**Our Case Number:** ABP-317660-23

**Re:** Bus Connects Kimmage to City Centre core bus corridor scheme  
Kimmage, Dublin

## **Bus Connects Dublin - Kimmage to City Centre Core Bus Corridor Scheme**

**Bord Pleanála Case reference: HA29N.317660**

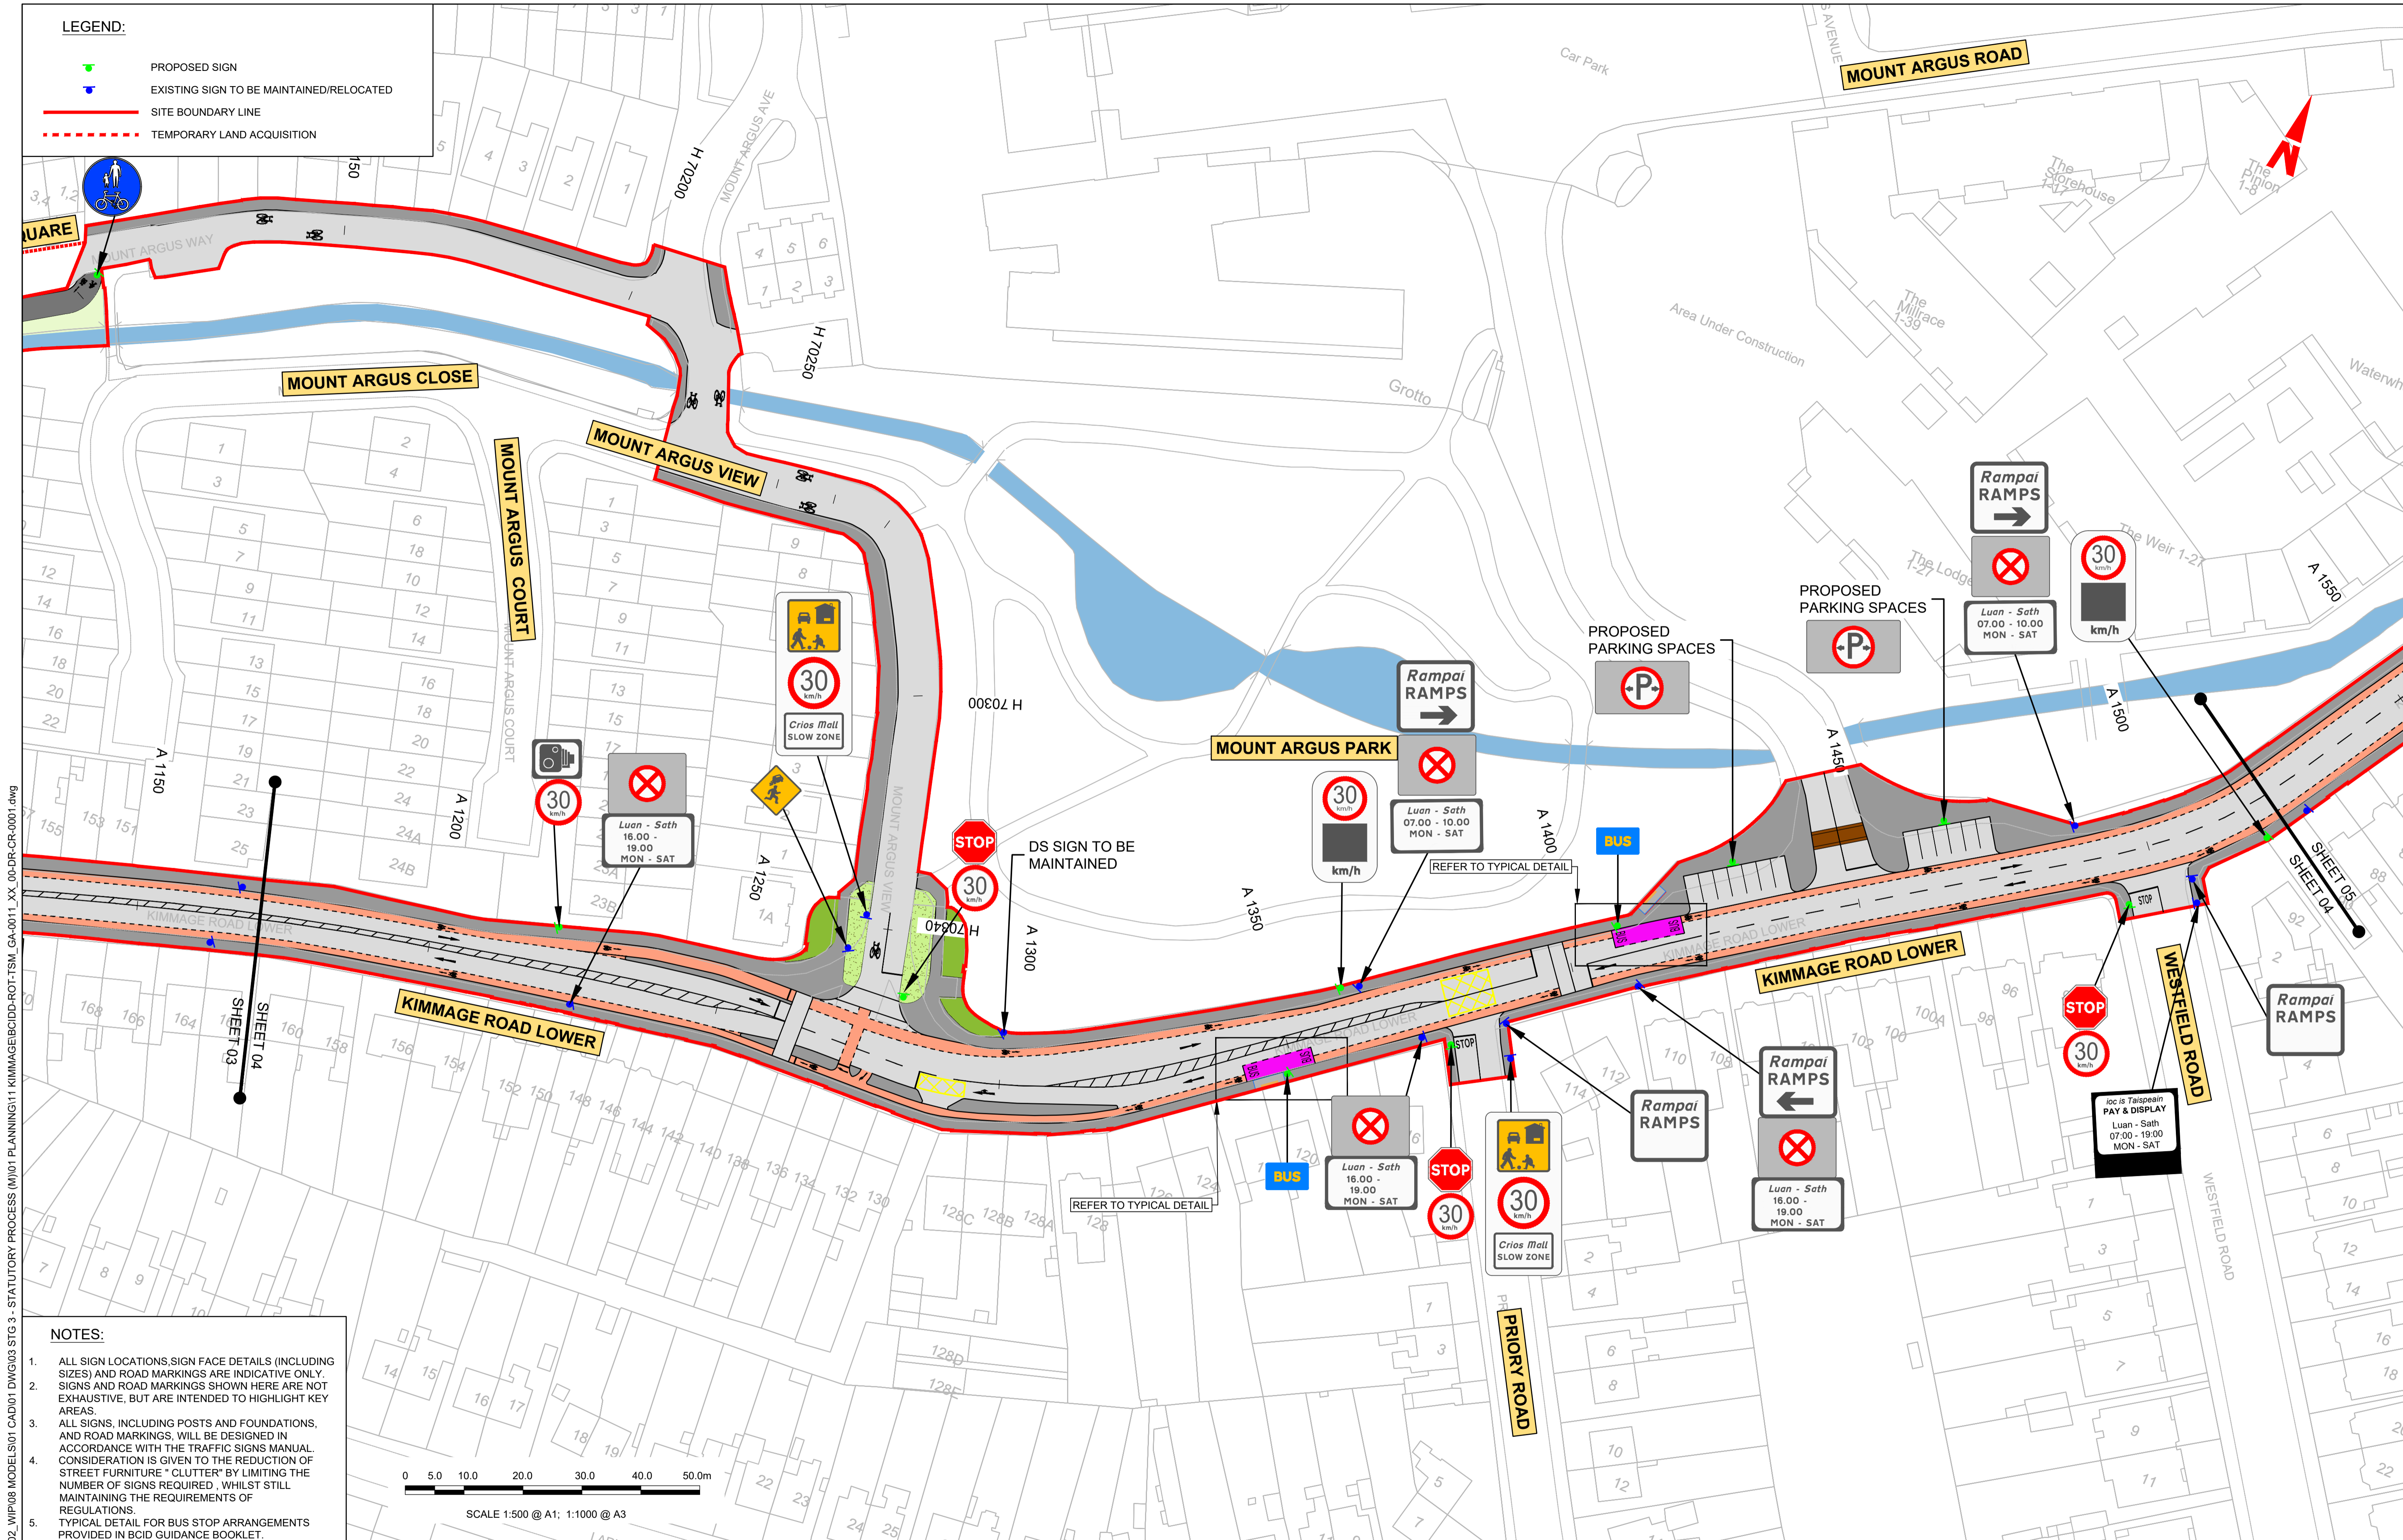
- This scheme drawing appears to suggest that allowance has been made for vehicular access and egress of the lane between 128C and 130 Kimmage Road Lower. Should the scheme be approved, this MUST be retained. If the road markings do not currently cater for unencumbered access and egress then it MUST do so. (Note: This lane is used for vehicular rear access for up to c.28 properties\*, with that lane being the ONLY FRONT and PRIMARY vehicular (and home occupants) access for properties 128D and 128E Kimmage Road Lower. (see Appendix 2).

**Road markings – provision for and maintenance of lane vehicular access:** This scheme drawing appears to suggest that allowance has been made for vehicular access and egress of the indicated lane – should the scheme be approved, this **MUST** be retained; if the Road markings do not currently cater for that unencumbered access and egress then it **SHOULD** do so.

**Road markings – provision for and maintenance of lane vehicular access:** This scheme drawing appears to suggest that allowance has been made for vehicular access and egress of the indicated lane – should the scheme be approved, this **MUST** be retained; if the Road markings do not currently cater for that unencumbered access and egress then it **SHOULD** do so.

**Note:** This lane is used for vehicular rear access for up to c.28 properties\*, with that lane being the **ONLY FRONT and PRIMARY** vehicular (and home occupants) access for properties 128D and 128E Kimmage Road Lower.

**I request that any road markings and traffic signage provide for the unencumbered access and egress to the lane between 128C and 130 Kimmage Road Lower.**
